Technical Note 1	
Leeds Road, Kirklees	
Job number:	J0737
Document number:	J0737/2/D1
Date:	18 January 2024
Client:	c/o KPP Architects
Prepared by:	Mr Bob Thomas

1.1.1 This technical note provides a response to comments made by Kirklees Council on the Air Quality Assessment submitted in support of the outline planning application for a warehouse at Leeds Road, Mirfield, application number 2023/60/92448/E. Kirklees Council Environmental Health (Pollution & Noise Control) provided a response on 11<sup>th</sup> September 2023, responding reference WK/202327411. With specific reference to air quality, the following comments have been made by Kirklees Council:

Figure 1: Measured Annual Mean NO₂ Concentrations at Diffusion Tube K6

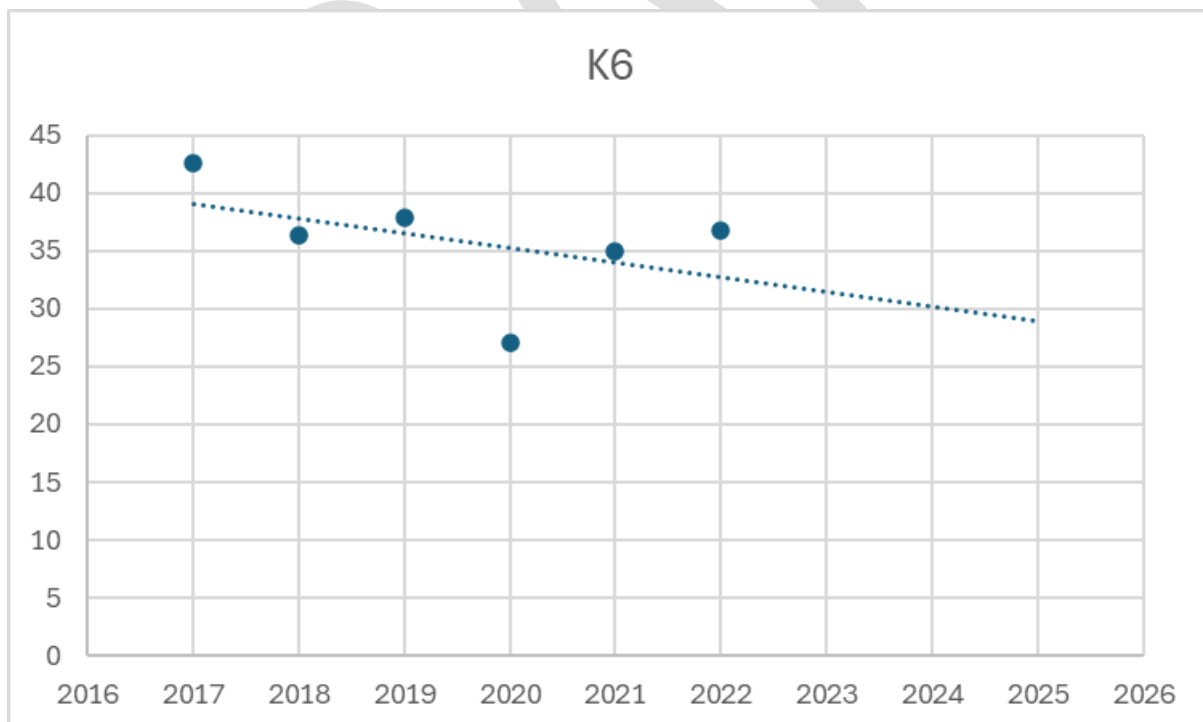
*K6 is the nearest roadside diffusion tube to Rose Cottage R1. According to our latest monitoring figures taken from the 2023 ASR which is yet to be approved by DEFRA, the 2022 annualised concentration for K6 at roadside is 36.8  $\mu\text{g}/\text{m}^3$  and at the nearest receptor façade is 31.2  $\mu\text{g}/\text{m}^3$ . However, the predicted modelled concentration for the 2025 Do Minimum (DM) and Do Something (DS) scenarios as depicted in the assessment is 20.0  $\mu\text{g}/\text{m}^3$  respectively. This would suggest a reduction of 11.2  $\mu\text{g}/\text{m}^3$  over 3 years, this requires further explanation given the nature of this extremely busy junction.*

- 2.3.4 Measured annual mean NO<sub>2</sub> concentrations at diffusion tube monitoring site K6 are represented in a graph in **Figure 1**. The graph also shows a trendline projected forward to 2025. There is a falling trend in annual mean NO<sub>2</sub> concentrations, with a projected annual mean concentration of around 29µg/m<sup>3</sup> at diffusion tube monitoring site K6 in 2025. The annual mean NO<sub>2</sub> concentration predicted at diffusion tube monitoring site K6 in 2025 without the proposed development is 21.4µg/m<sup>3</sup>. Therefore, assuming annual mean NO<sub>2</sub> concentrations continue to decrease at diffusion tube monitoring site K6 at the same rate as between 2017 and 2022, the model may underpredict concentrations at this location.

- 2.3.5 Receptor R1 is close to diffusion tube monitoring site K6, but at the façade of a dwelling approximately 9m further from the kerb of the A62 than the monitoring site. The predicted annual mean NO<sub>2</sub> concentration at receptor R1 is 1.4µg/m<sup>3</sup> lower than

at the monitoring site in 2025. Therefore, an estimate of the 2025 annual mean NO<sub>2</sub> concentration at receptor R1, based on the decreasing trend in annual mean concentrations at diffusion tube monitoring site K6, is around 28µg/m<sup>3</sup>, well below the annual mean objective of 40µg/m<sup>3</sup>.
